## **Suffolk County Council (20041323)**

**Response to the Applicant's Comments on  
any other submissions received at Deadline 4**

## **Bramford to Twinstead (EN020002)**

<b>Table 1: SCC Table of Comments on 8.7.3 (A) Applicant’s Comments on the SCC D4 Submission (Table 2.1) [REP5-025]</b>			
<b>Ref</b>	<b>Matter</b>	<b>Applicant’s Comments</b>	<b>SCC’s Response</b>
<b>Comments on Responses to ExA’s First Written Questions [REP4-033]</b>			
1a, 1b, 1c	Socio-economics and other community matters: Employment	<p>The worker numbers in the Socio Economics and Tourism Report [APP-066] have been calculated by one of the Applicant’s Framework Contractors who is experienced in delivering this type of project for the Applicant. The resourcing levels have then been overlaid on the construction schedule to generate the resource histogram used in the Socio Economics and Tourism report [APP-066].</p> <p>The majority of employment activities would require trained specialists who are qualified to work on National Grid infrastructure, and these would be sourced through an appointed Main Works Contractor from an existing pool of approved framework contractors.</p> <p>Experience based on other Na

DEDHAM VALE EAST SEALING END COMPOUND:
 PLAN VIEW
 SCALE 1:200

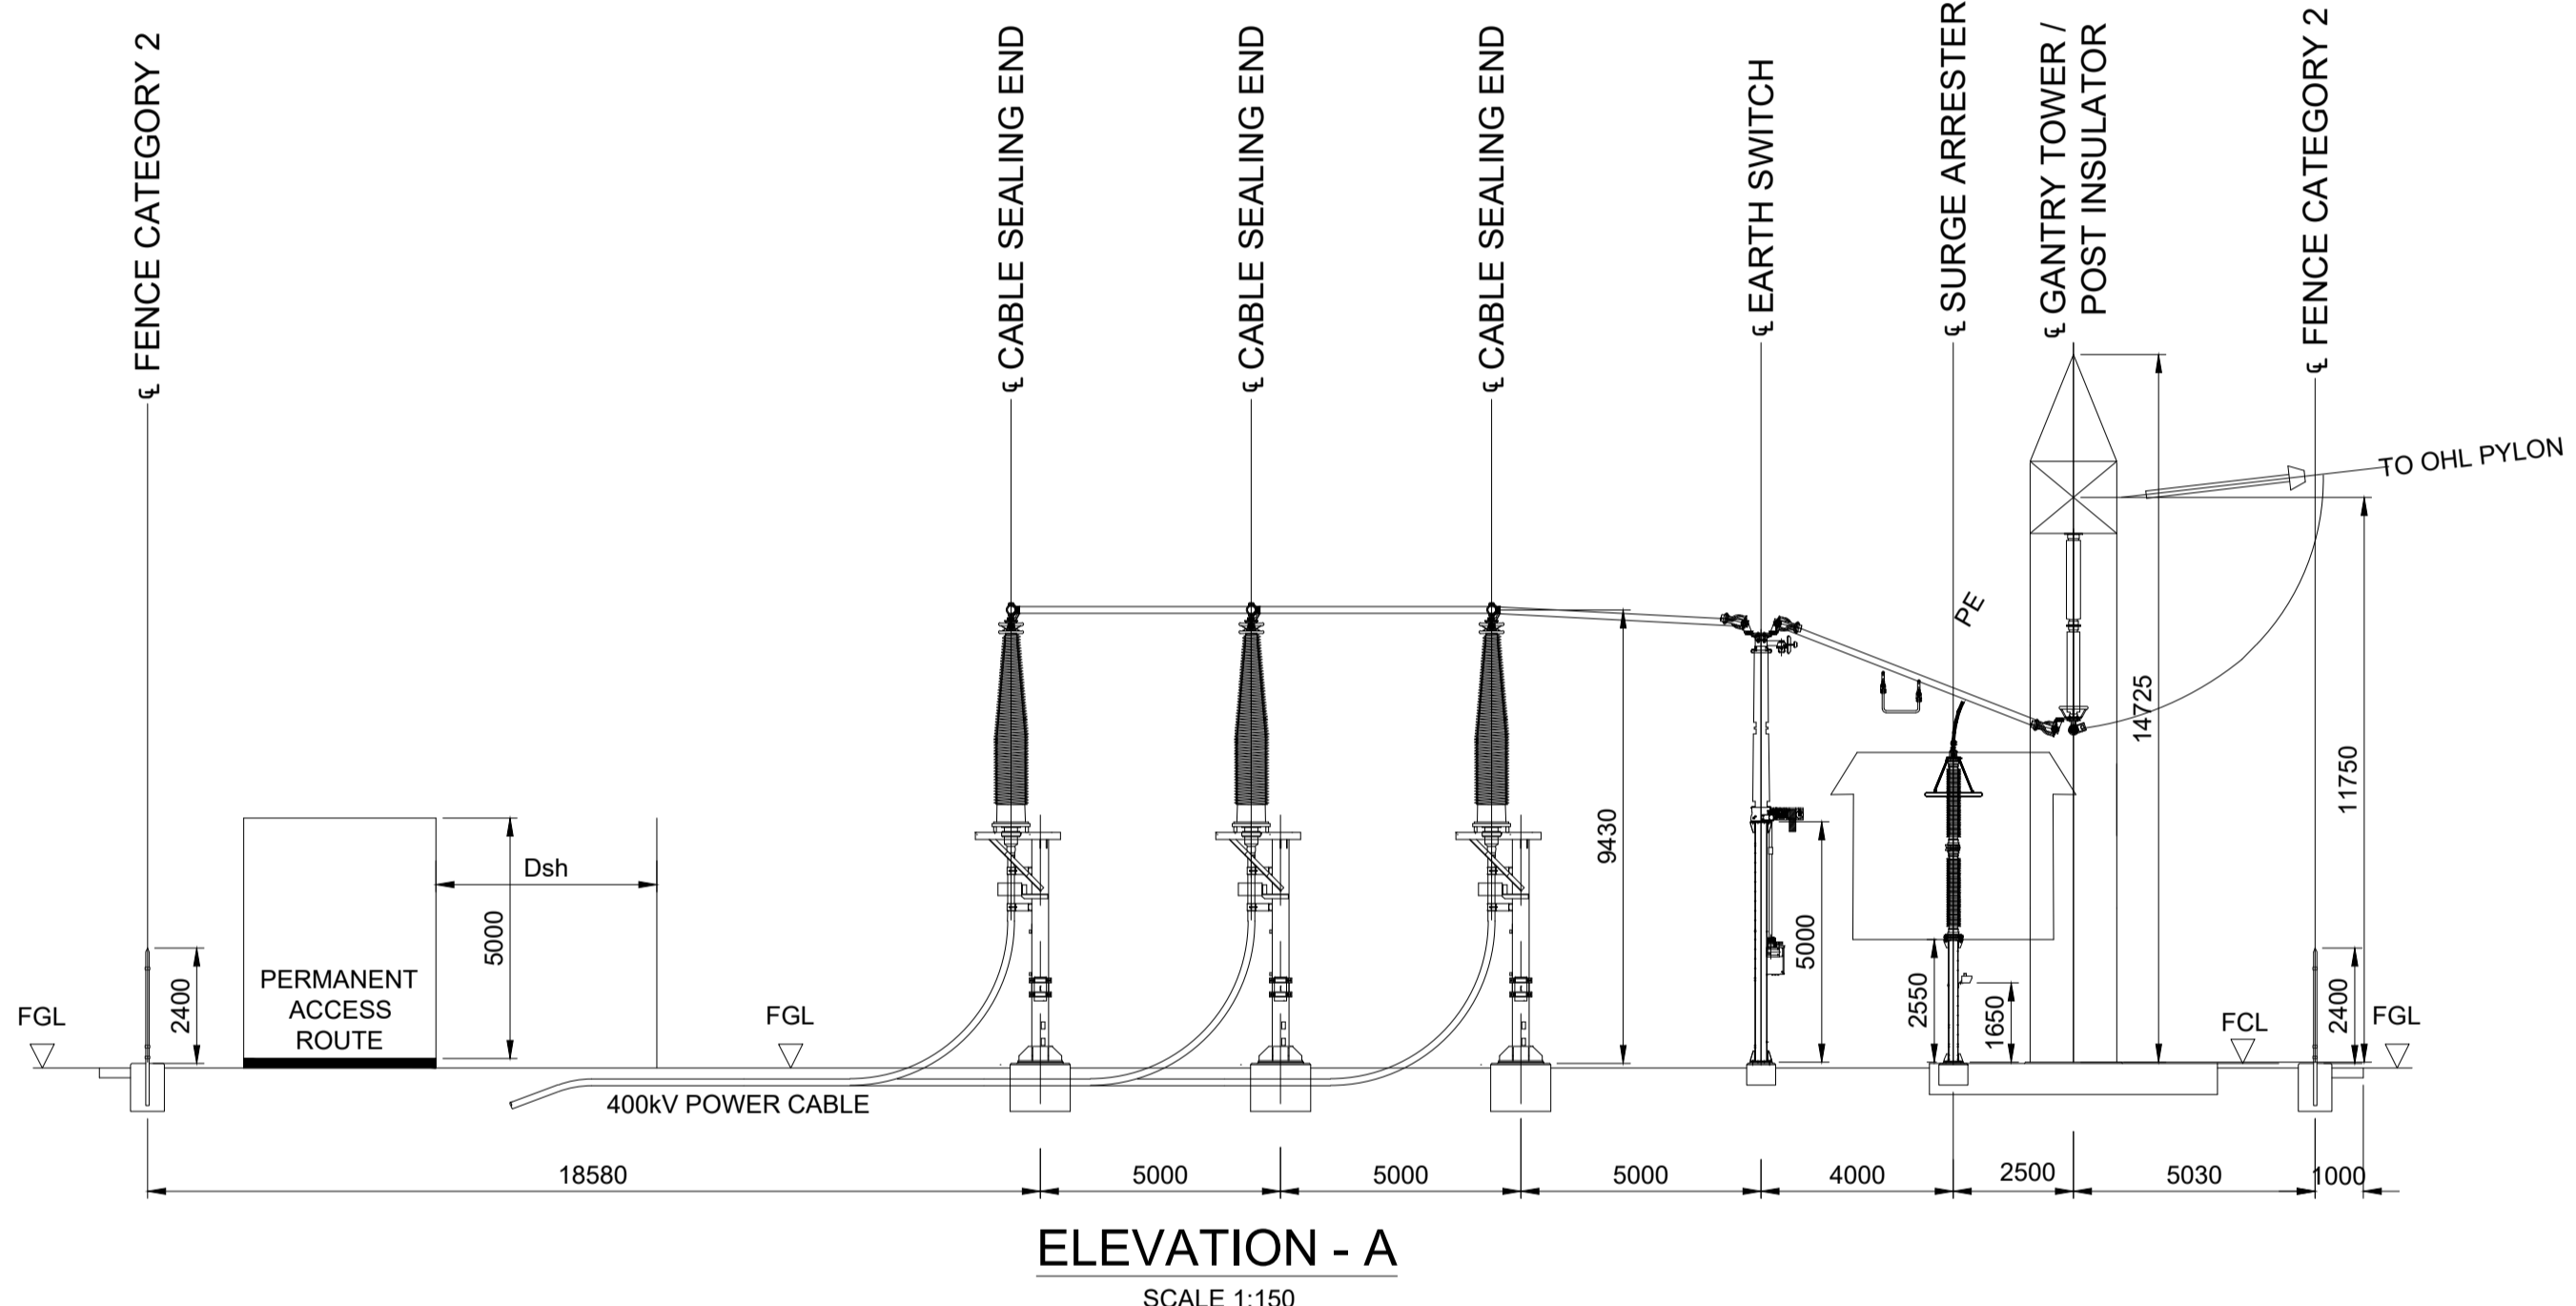
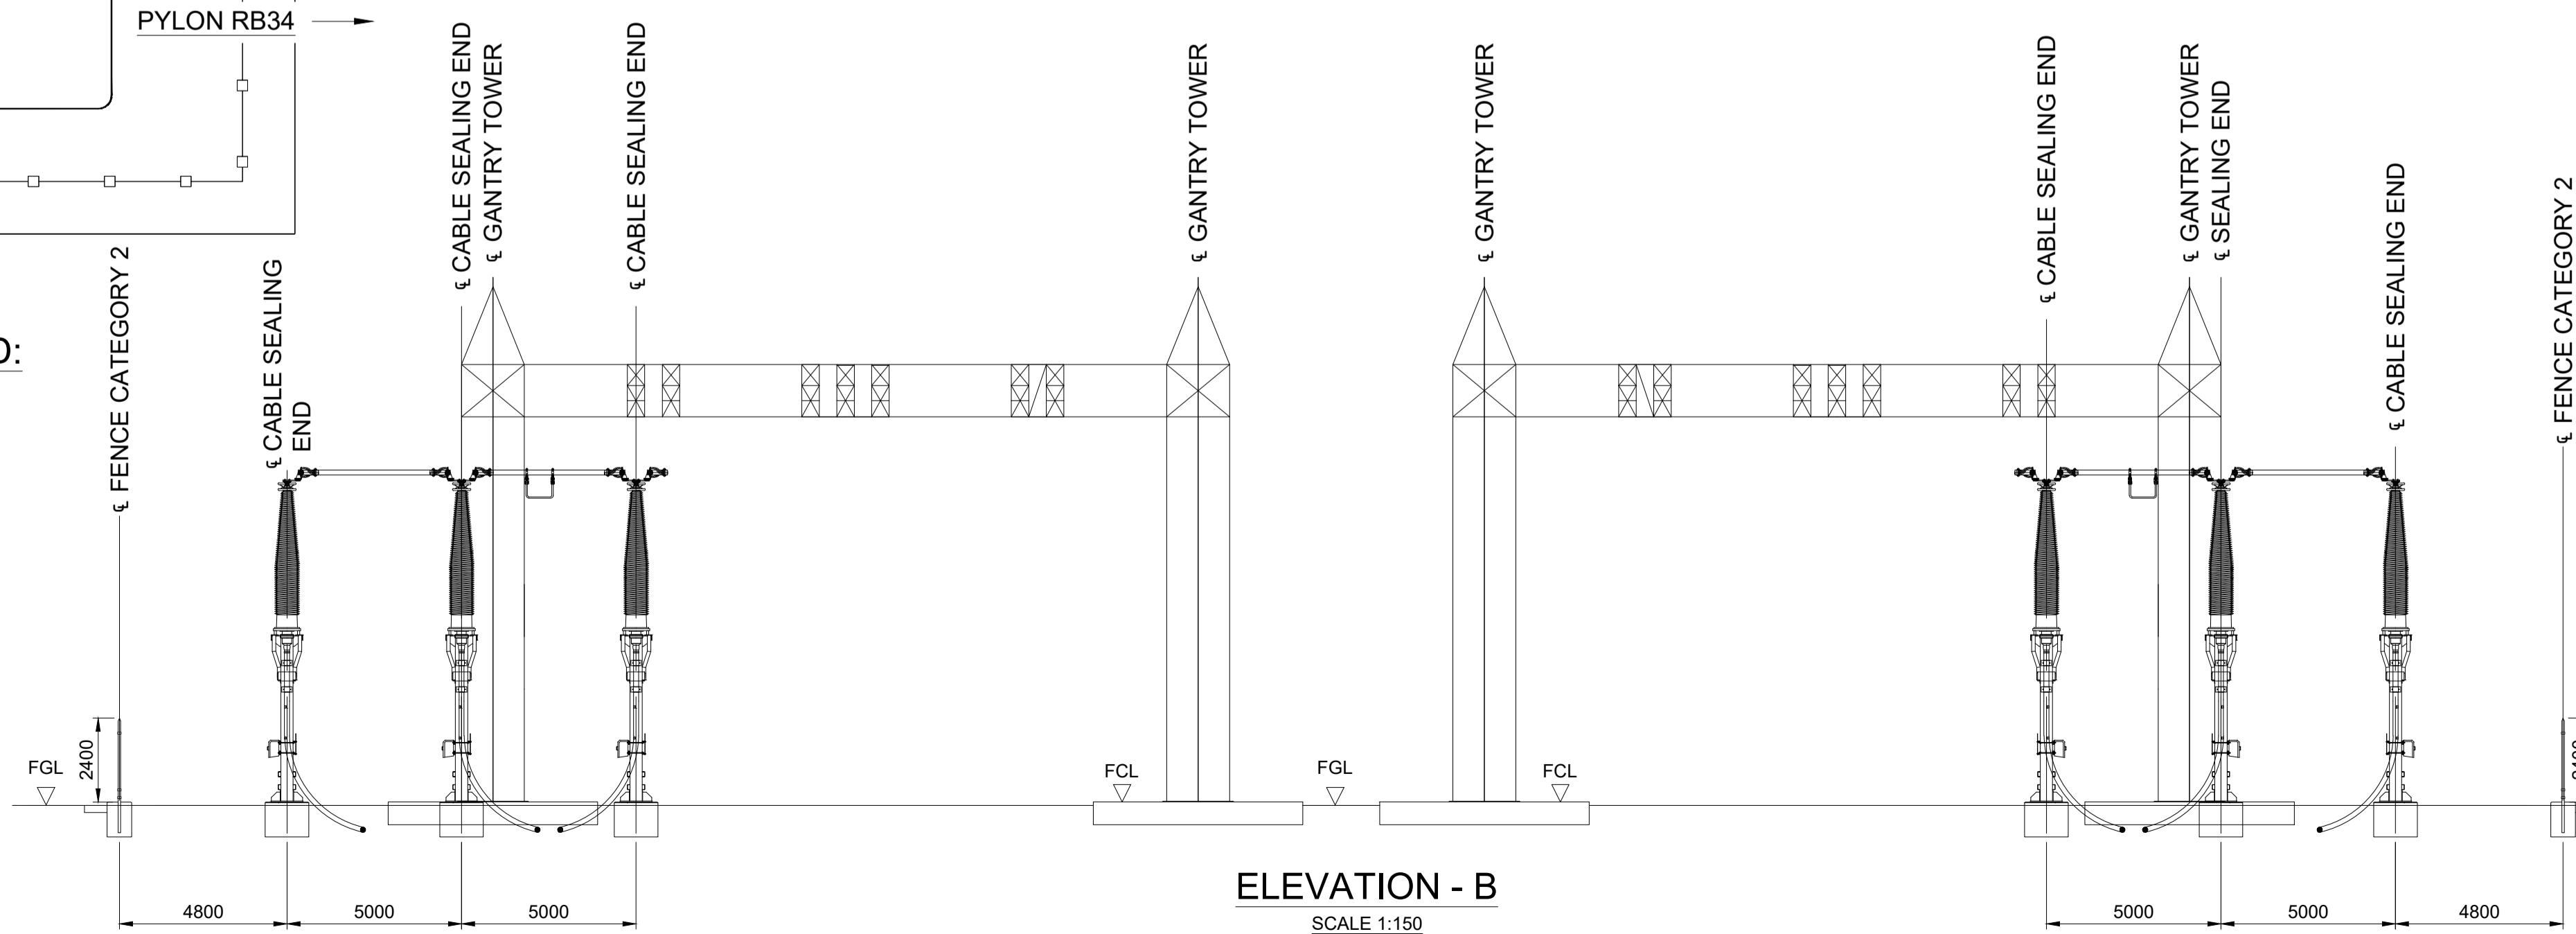
5.5	<p>Location of the Dedham Vale east CSE compound</p>	<p>The Applicant notes that the Councils agree with the location for the Dedham Vale East CSE compound, as stated in the LIR.</p> <p>The location of Dedham Vale East CSE compound balances engineering and environmental aspects. In its current location, residential properties benefit from screening from existing vegetation, and the location is also screened in views from the edge of the AONB as shown in Viewpoint E-10 at ES Appendix 6.4 Viewpoint Assessment [APP-104]. A location more central between Millwood Road and Heath Road would increase the landscape and visual impacts as it would be visible from Viewpoint E-10, would be closer to a PRow and would potentially require vegetation removal to maintain the distance from the existing overhead line being retained.</p> <p>Embedded planting is shown on Sheet 12 of Landscape and Ecological Management Plan (LEMP) Appendix B: Vegetation Reinstatement Plan [REP3-036]. This includes for a hedgerow with trees along Millwood Road and a hedgerow along the northern boundary of the site. The hedgerow is reinforced by two blocks of scrub planting which have been positioned to screen</p>	<p>SCC (Landscape) would note that additional mitigation planting and appropriate management of the mitigation planting is likely to be required. This would include further hedge/scrub planting along the access road to conceal views into the site from the access point. This has been discussed in the thematic meeting on 12 December 2023.</p>

5.7	Sufficiency of visual mitigation for the CSE compounds - DedhamVale East CSE Compound	Noted. The hedgerow planting is part of this embedded measure as shown on Sheet 12 of LEMP Appendix B: Vegetation Reinstatement Plan [REP3-036].	SCC (Landscape) is awaiting changes. Matter remains under discussion.
